From: [REDACTED]
Sent: 26 February 2024 16:23
To: Planning
Subject: Planning Application Number 3/2024/0076 Land Off Hammond Drive, BB12 7RERead, BB12
Attachments: Photograph 1.jpg; Photograph 2.jpg; Photograph 3.jpg

[REDACTED] please accept this communication as confirmation of our objection to planning application number 3/2024/0076 – resubmission of planning application number 3/2023/0447 Land off Hammond Drive, Read, BB12 7RE.

Existing  
Site Layout

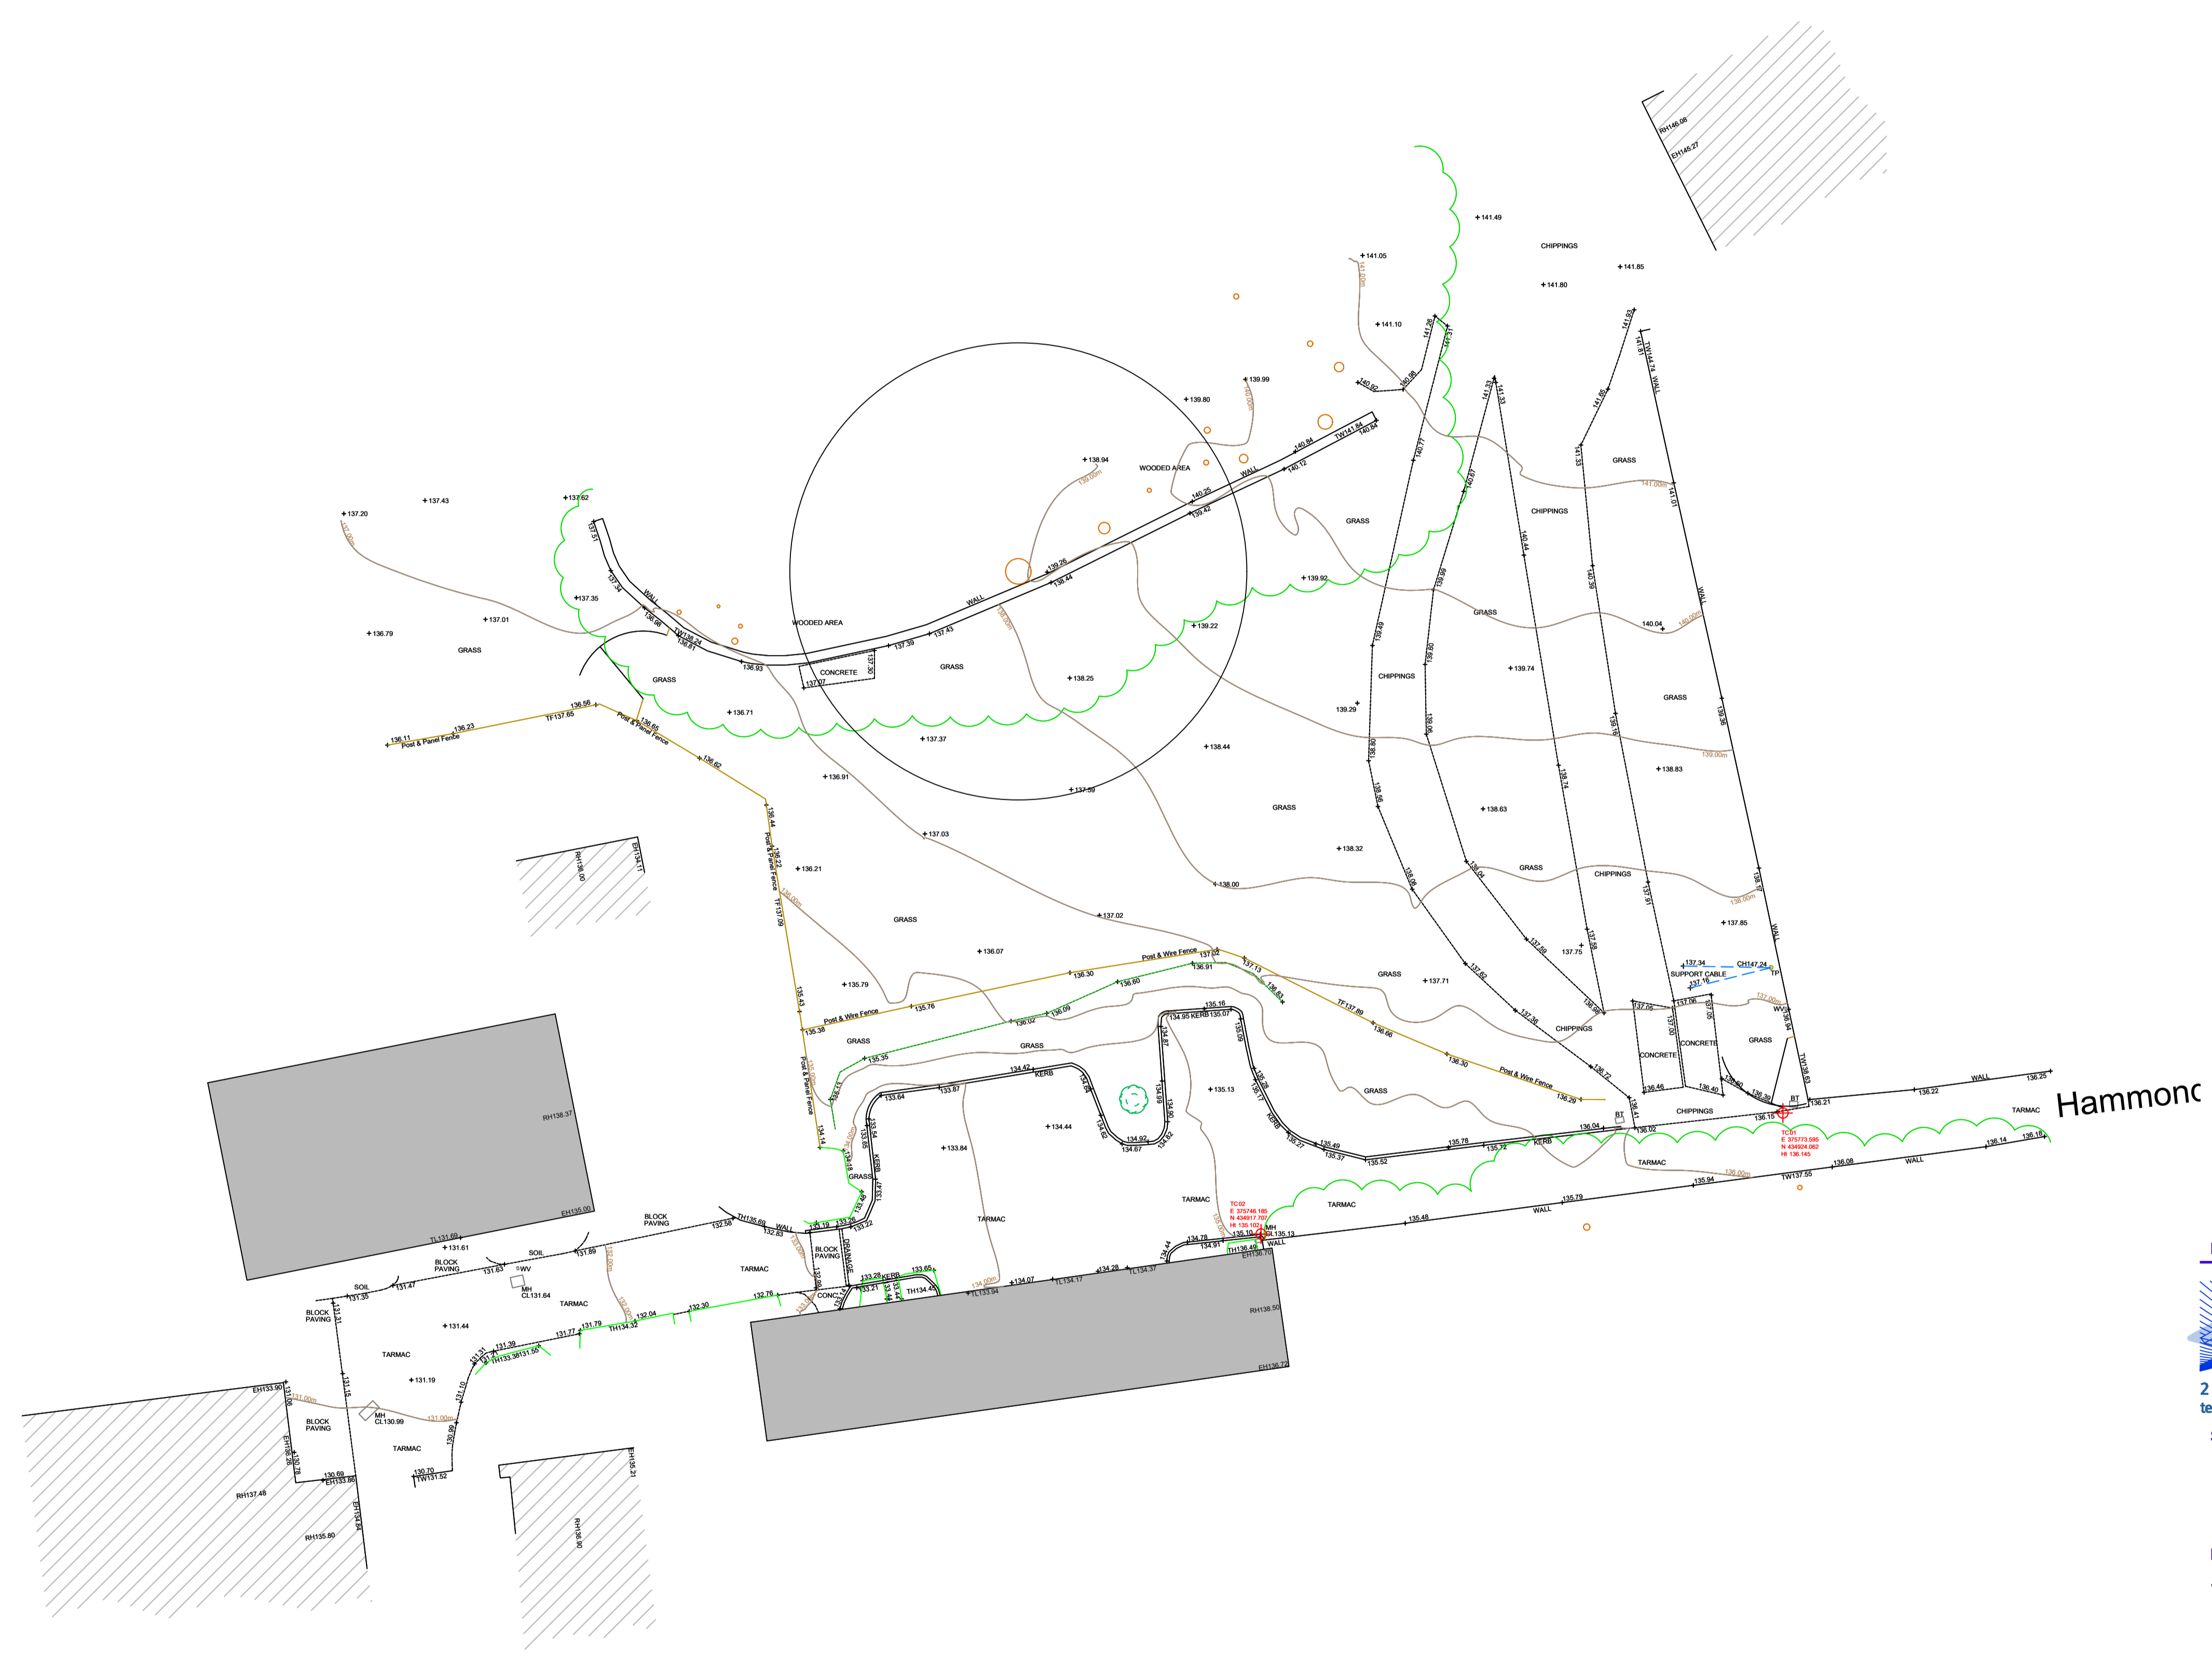
To say that the dwelling will be inconspicuous is almost laughable. We are not topography experts, but it is plain to see from the proposed site plan and the topographical survey that the dwelling will be quite clearly conspicuous from both Hammond Drive [REDACTED]

The car parking on Hammond Drive [REDACTED] is at a level of circa 134 metres above sea level, which means that the dwelling will be approximately 3 metres above the road level at its lowest point and 5.8
